From: Longridge Town Council <longridgetc@gmail.com>
Sent: 03 February 2016 14:08
To: planning
Cc: 'Longridge Town Council'
Subject: Comments on planning applications

Longridge Town Council would like to make the following observations:

Planning Application No: 3/2015/1024
Proposal: Erection of two detached dwellings.
Location: Dilworth Coach House 41 Dilworth Lane Longridge PR3 3ST

PROPOSED SITE PLAN SCALE 1:200

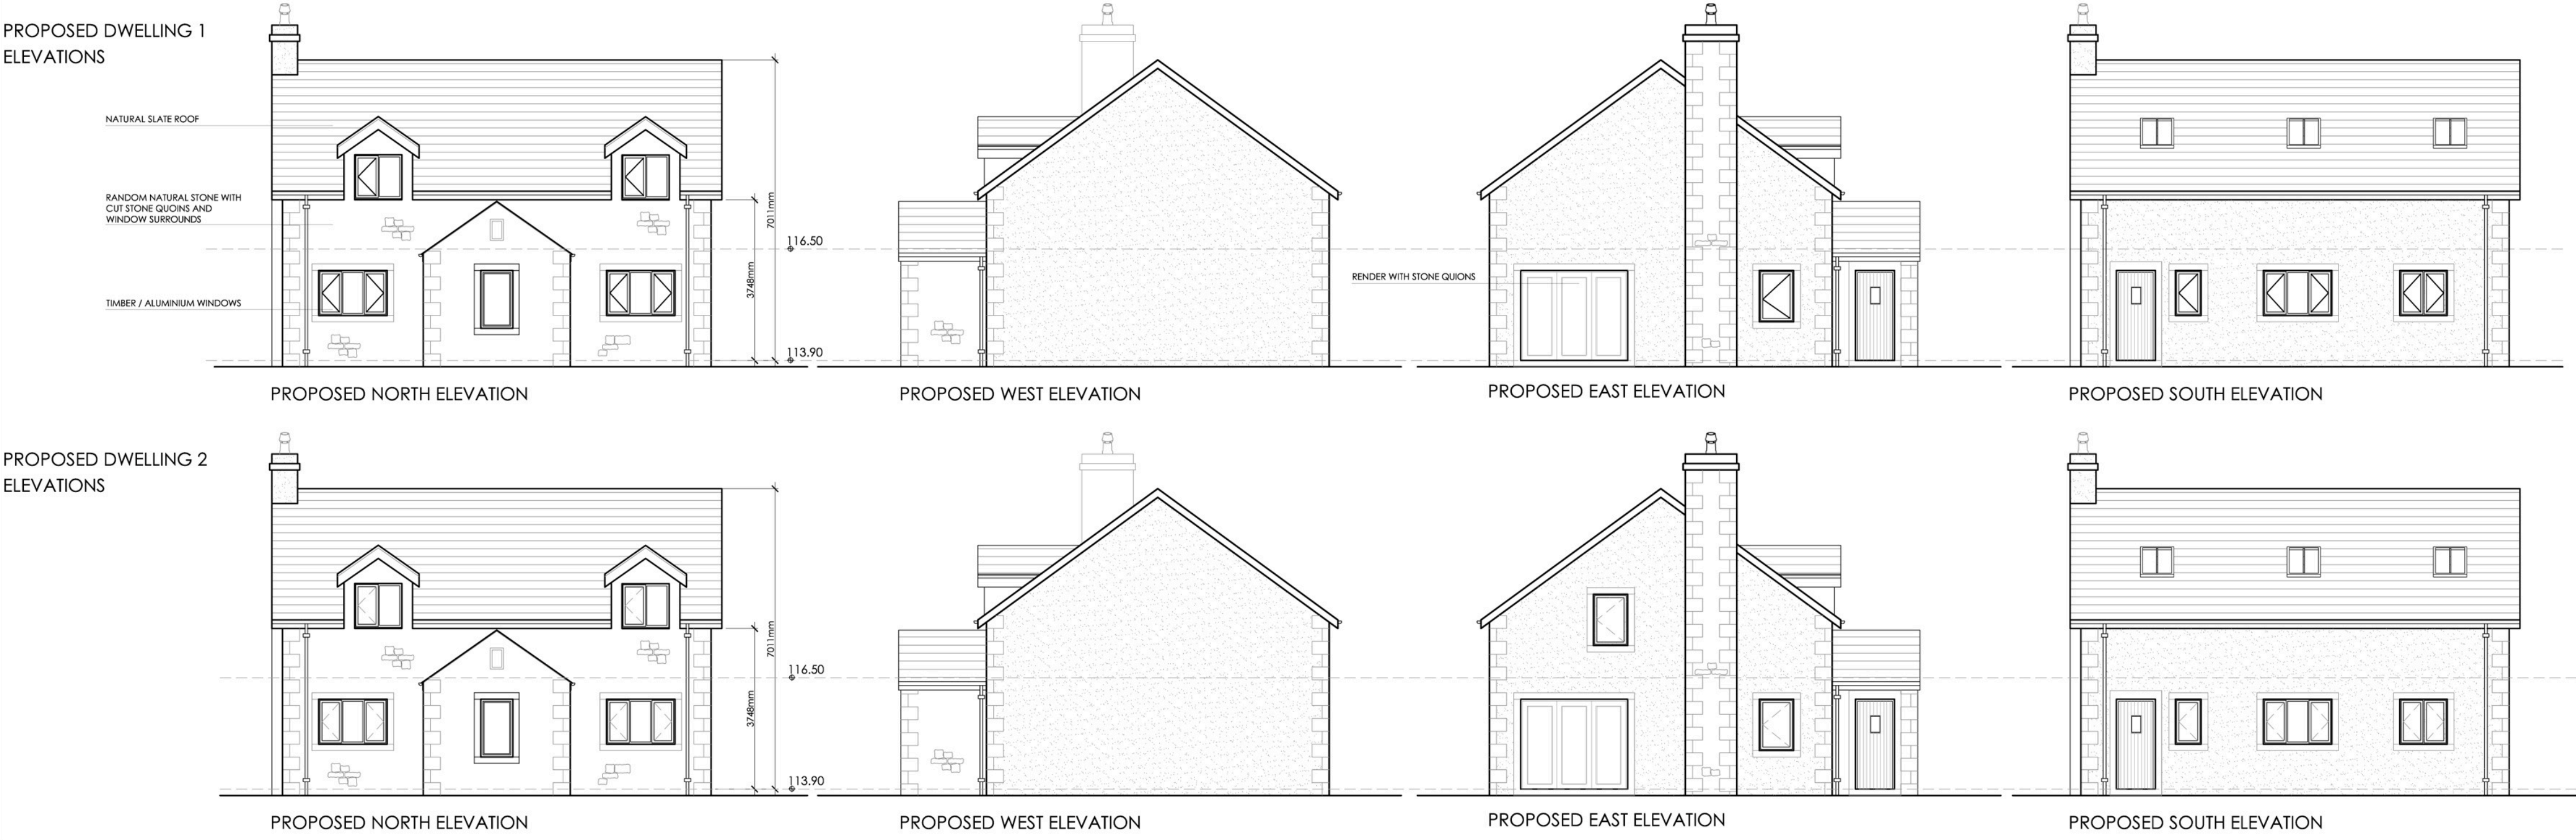
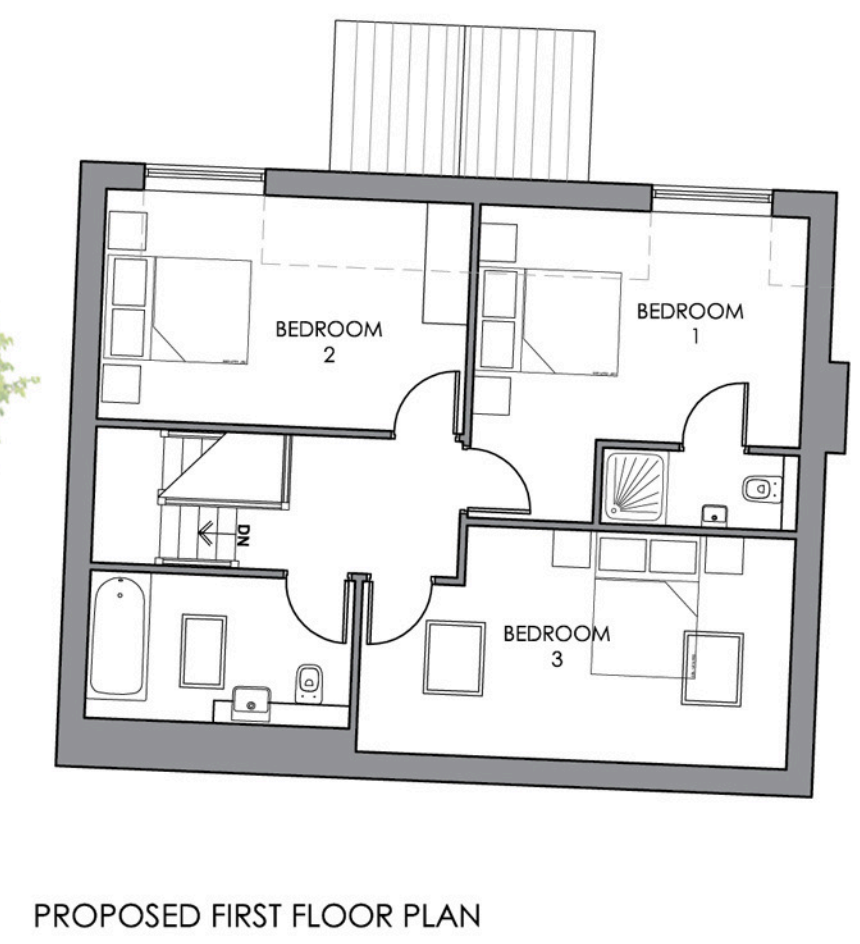
LTC: No objection but would ask for privacy distances to be checked.
